Response to Planning Application

From: Arun District Council Greenspace

Application ref: WA/32/21/PL

Description: Construction of 30 No. dwellings together with associated access, parking, public open space & landscaping. This site may affect the setting of listed buildings, affects the character & appearance of the Walberton Green Conservation Area, is a Departure from the Development Plan & is in CIL Zone 3 & is CIL Liable as new dwellings.

Drawing Title
DRAINAGE LAYOUT
2 of 2

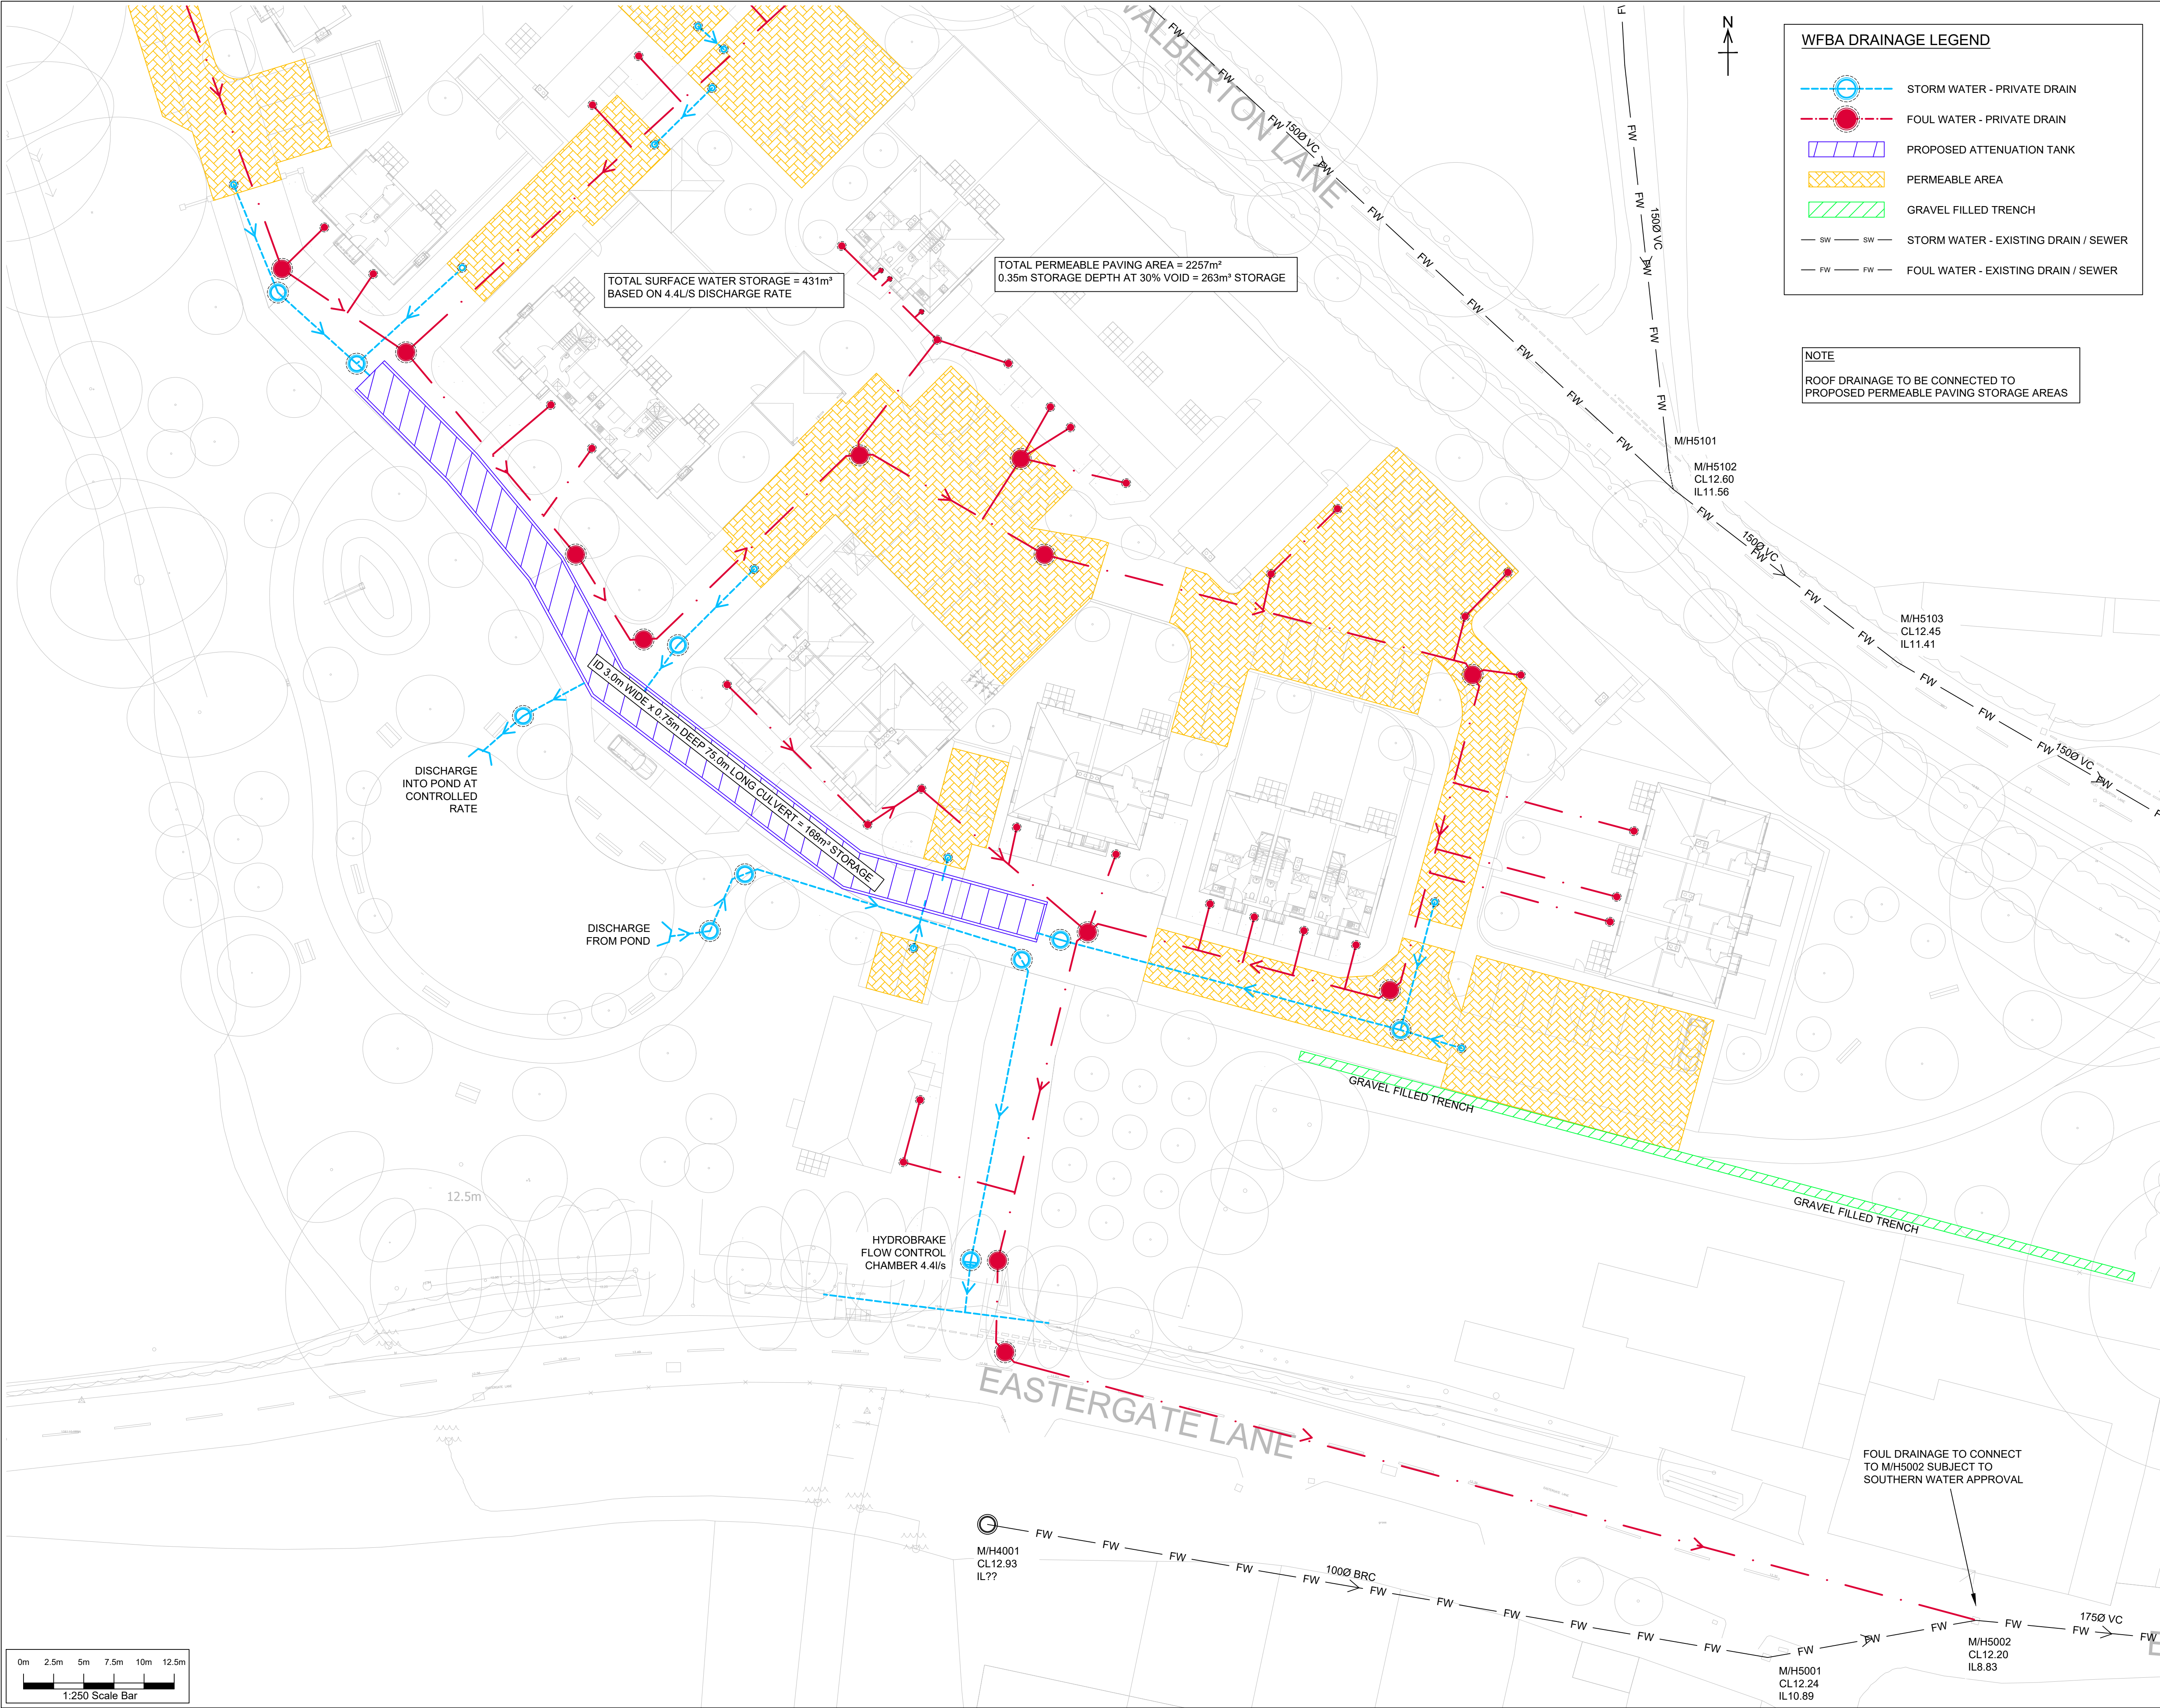
The layout plans will need to detail areas to be used as SuDS features. SuDS are required to be fitting with the development and well designed to be an asset to the site, to provide interest, visually and biodiversity enhancement. Existing watercourses within the site to be protected from change. This development has watercourses in 3 sections. In addition, there is a ditch along the length of the Eastergate Lane section which should be kept clear for water to flow freely in to Walberton Pond.
